A66 NTP - Principal Areas of Disagreement Summary Statement of Cumbria County Council and Eden District Council for Examination Deadline 5, 14th March 2023

Drawing Title: De-trunking Plan Regulation 5(2)(o) Sheet 1 of 1

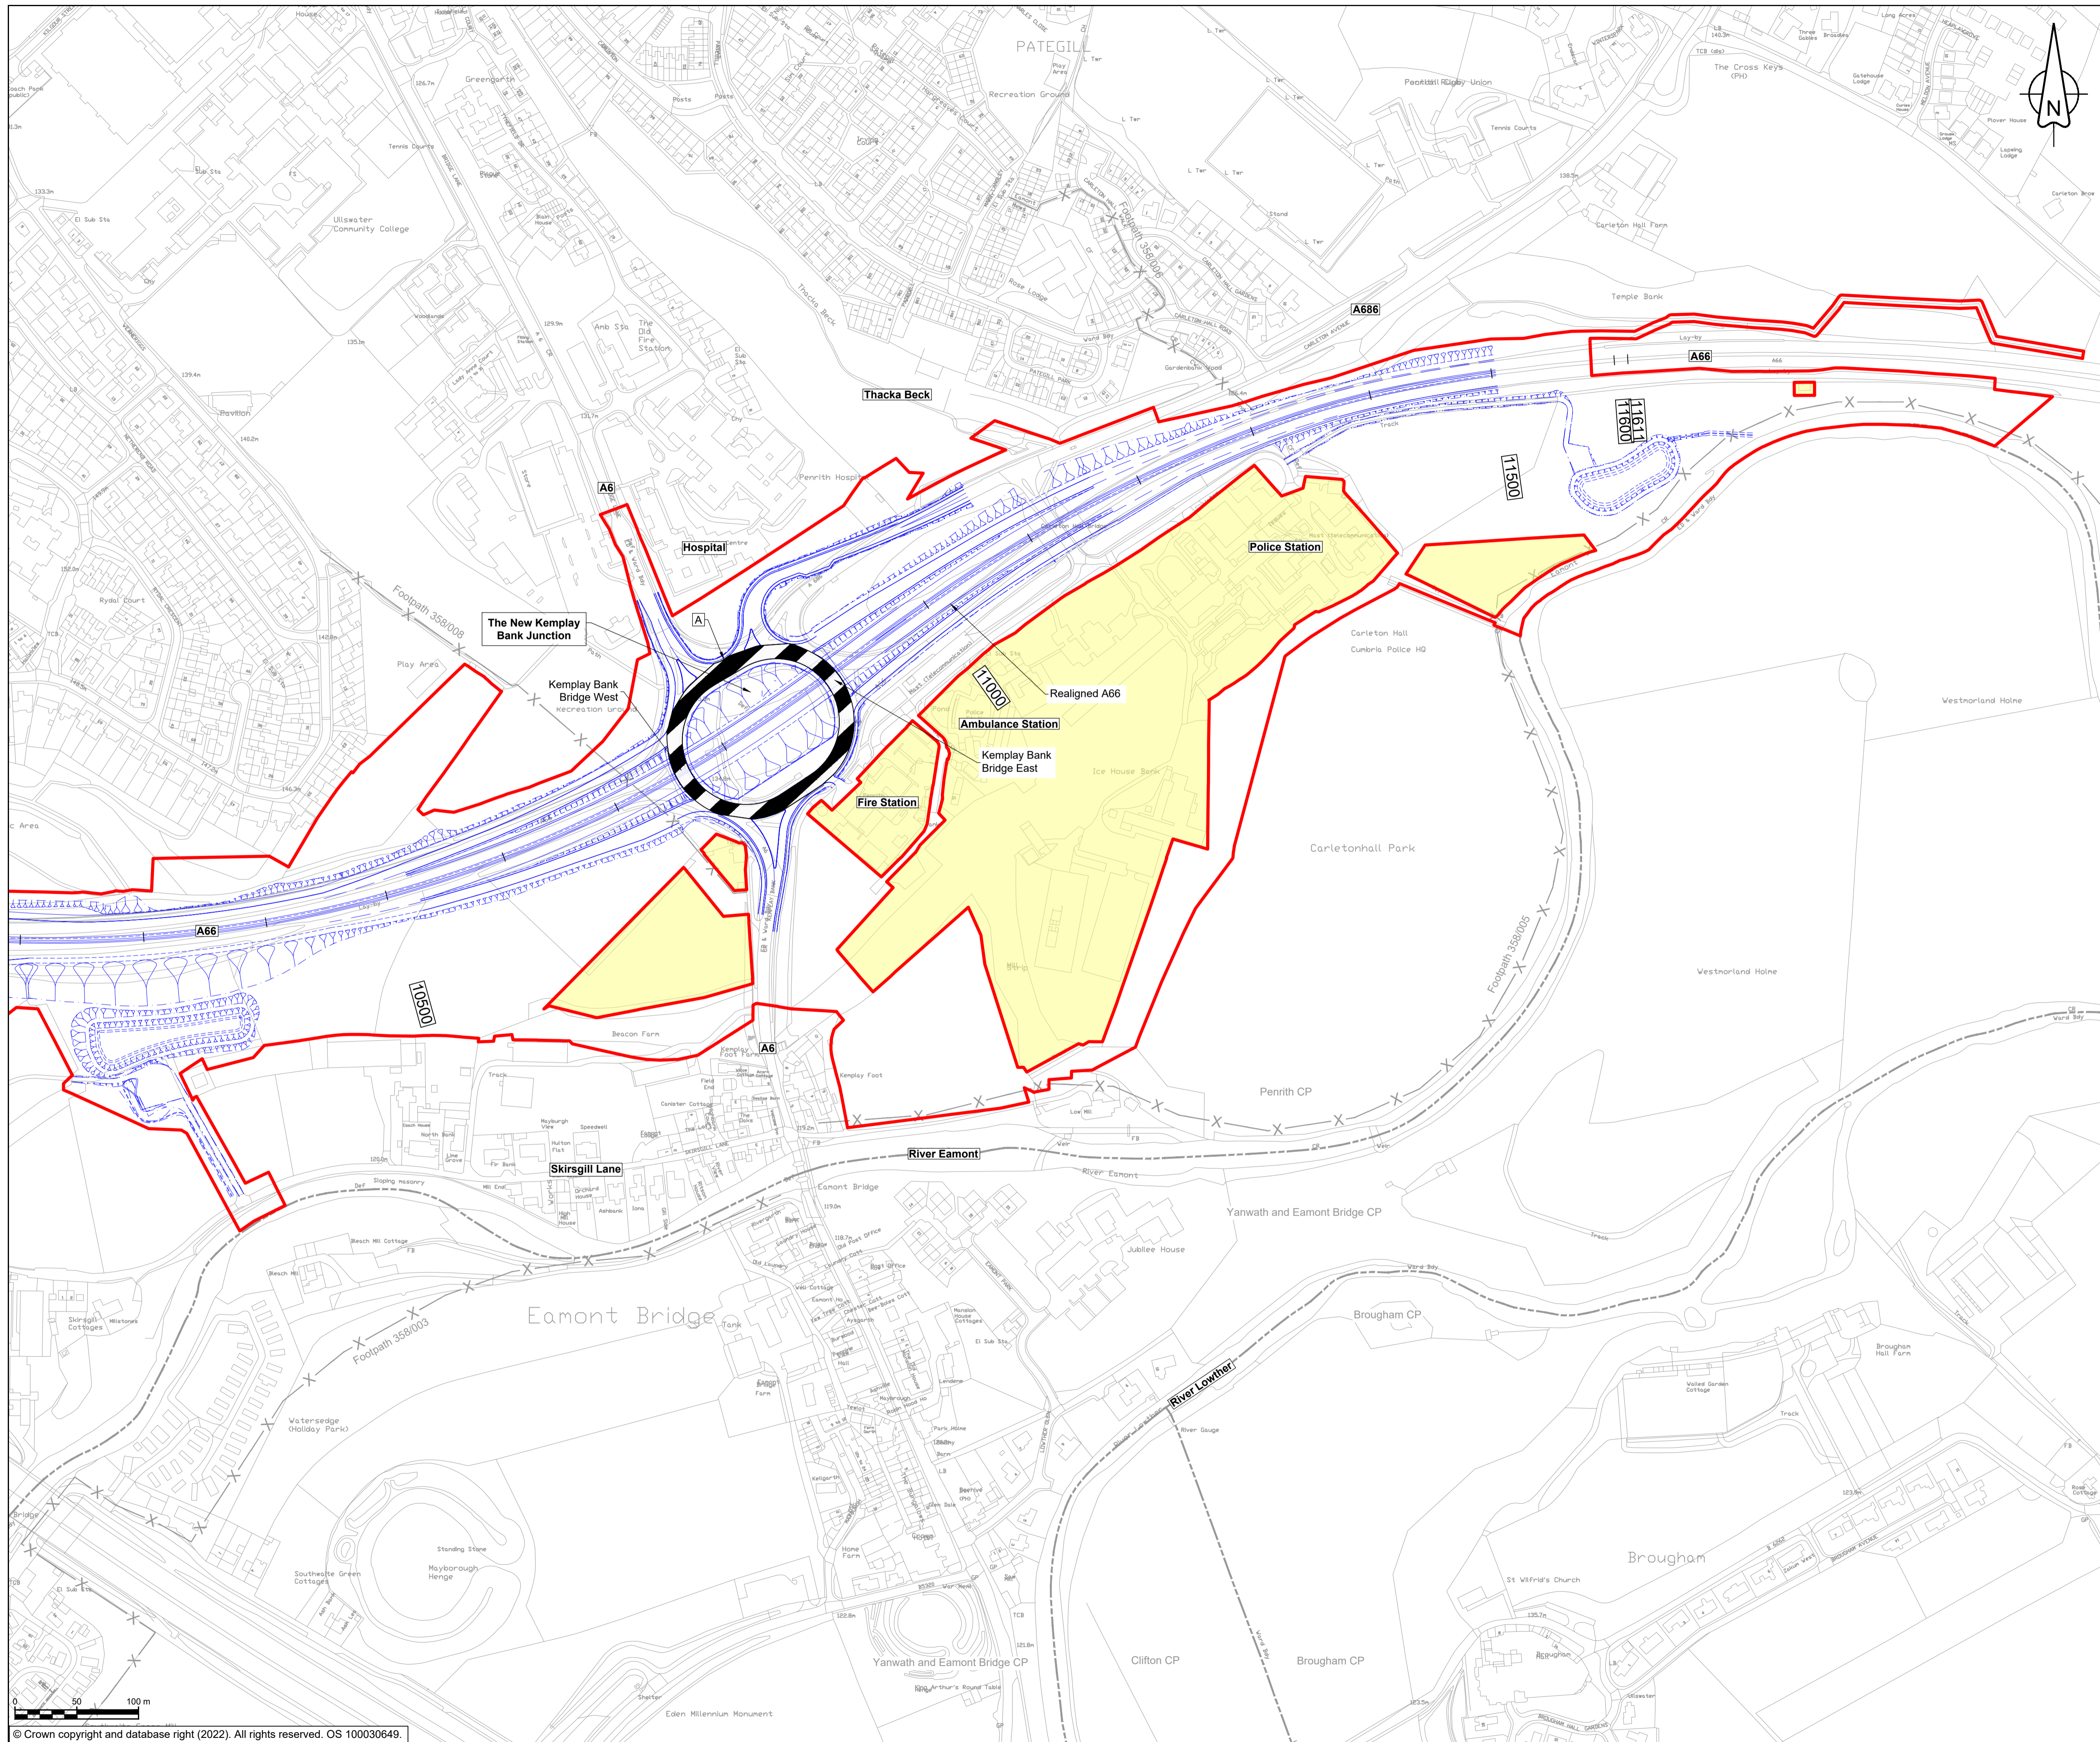
<p>Detrunking (road and structures)</p>	<p>Lack of detail in the dDCO provisions as to what assets will transfer to the Council as a result of detrunking. The Council needs to be assured that the detrunking proposals are acceptable in respect of:</p> <ol style="list-style-type: none"> 1. Maintenance liabilities & maintenance boundaries per asset type; 2. The condition of the detrunked assets backed up with appropriate records and assessments; 3. The design suitability of the asset (appropriate to the proposed use); 4. The provision of funds to maintain the asset. <p>The Council's specialist has discussed the detailed records for all asset types and welcome the Applicant's proposal which is in line with the Council's principles document, Appendix A to the LIR [REP1-019].</p> <p>Principal outstanding items include Crackenthorpe Retaining Wall, a potential major maintenance liability that will not be accepted by the Council without a full understanding of the structure and assessment of risks and liabilities. Walk Mill High Bridge includes liability due to high alumina cement used in construction.</p> <p>The Council must not inherit a maintenance liability and must be funded appropriately to maintain the full suite of detrunked assets.</p>	<p>The Applicant and the Local Highway Authorities must continue to work together to reach an agreed position on matters of principle and detail.</p> <p>The structures present a major risk to the Councils and it will require specialist technical advice and potentially investigation to quantify the risks and liabilities which it will be required to take on. The process for addressing the concerns and (if agreed) providing a commuted sum to offset the risks through the DCO process needs to be signed up to by all parties through a side agreement.</p> <p>Any remedial works determined to be undertaken by W&FC immediately after project completion, should be undertaken by the Applicant as part of the Project before hand over.</p> <p>Side agreements to be reached covering the de-trunking process and to include for the consequence of the Project to significantly increase the assets to be maintained by the Councils should have a direct compensation and not be reliant on unsecured future funding strategies.</p>	<p>The Councils' specialist has discussed the detailed records for Crackenthorpe and welcome the Applicant's proposal.</p> <p>The Councils note the Crackenthorpe bored pile wall and aged retaining wall must be resolved together.</p> <p>The Councils have concerns about the high alumina cement content in the Walk Mill High structure. Certainty through additional testing and assessment to prove adequate condition of all assets is required before handover, otherwise the Applicant must retain asset ownership, as stated in their draft document included in the side agreement.</p> <p>The side agreement calculation for commuted sums payable to W&FC should not include the requirement for the Council to undertake works immediately after the Project is complete.</p>
